OXFORDSHIRE COUNTY COUNCIL'S RESPONSE TO CONSULTATION ON THE FOLLOWING DEVELOPMENT PROPOSAL

Application no: 21/02083/REM

Proposal: Reserved matters application to 18/00792/OUT - for the demolition of existing buildings and erection of up to 46 no. dwellings, with associated works and provision of open spaces

Location: Land at Tappers Farm, Oxford Road, Bodicote, Banbury

Drawing Title:
 Infiltration System
 Part 1/2

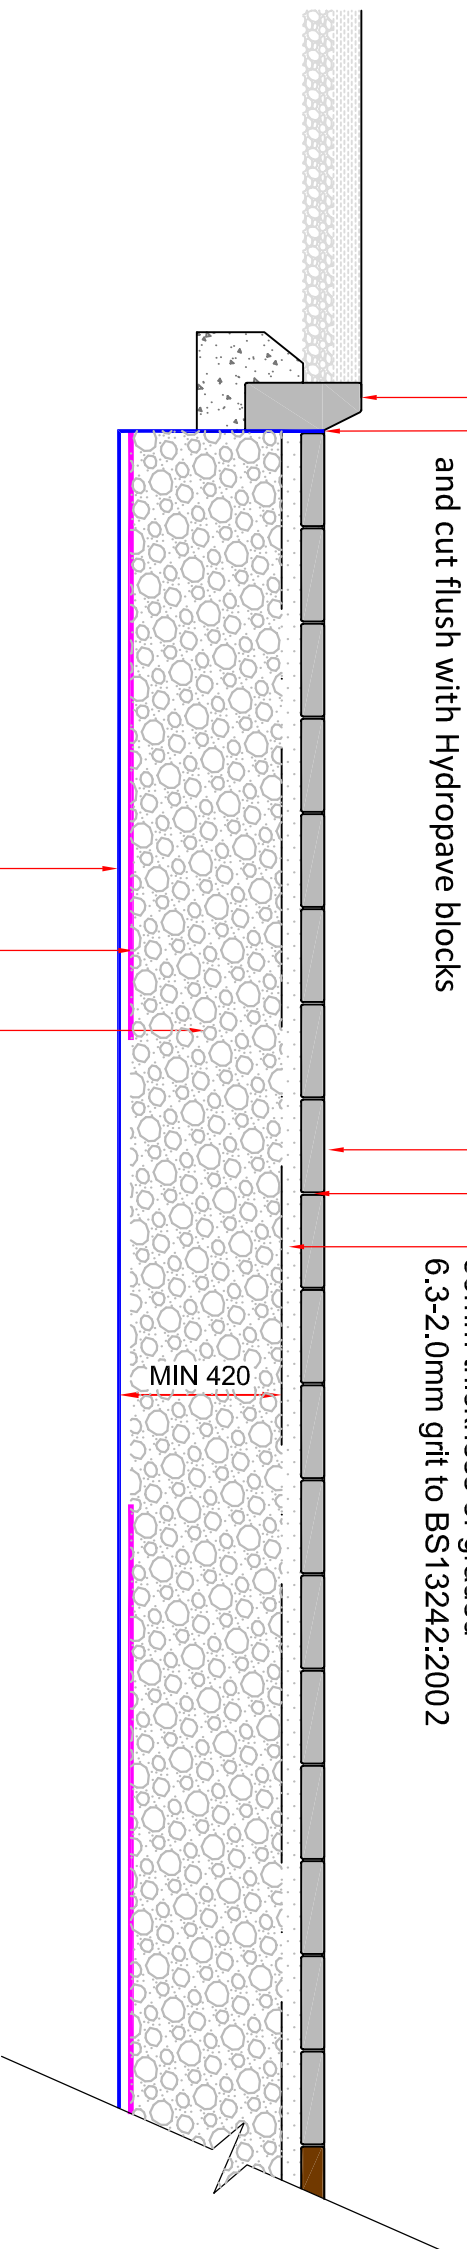
Where calculation shows Total Area (ha) 0.020, this must be reflected on the drawing. Where was this figure derived from? If this is the area of infiltration, this must be shown on the drainage drawing. Where runoff is to be infiltration on private plots, this must also be shown in the drawing.

Drawing must also show the exceedance flow routes.
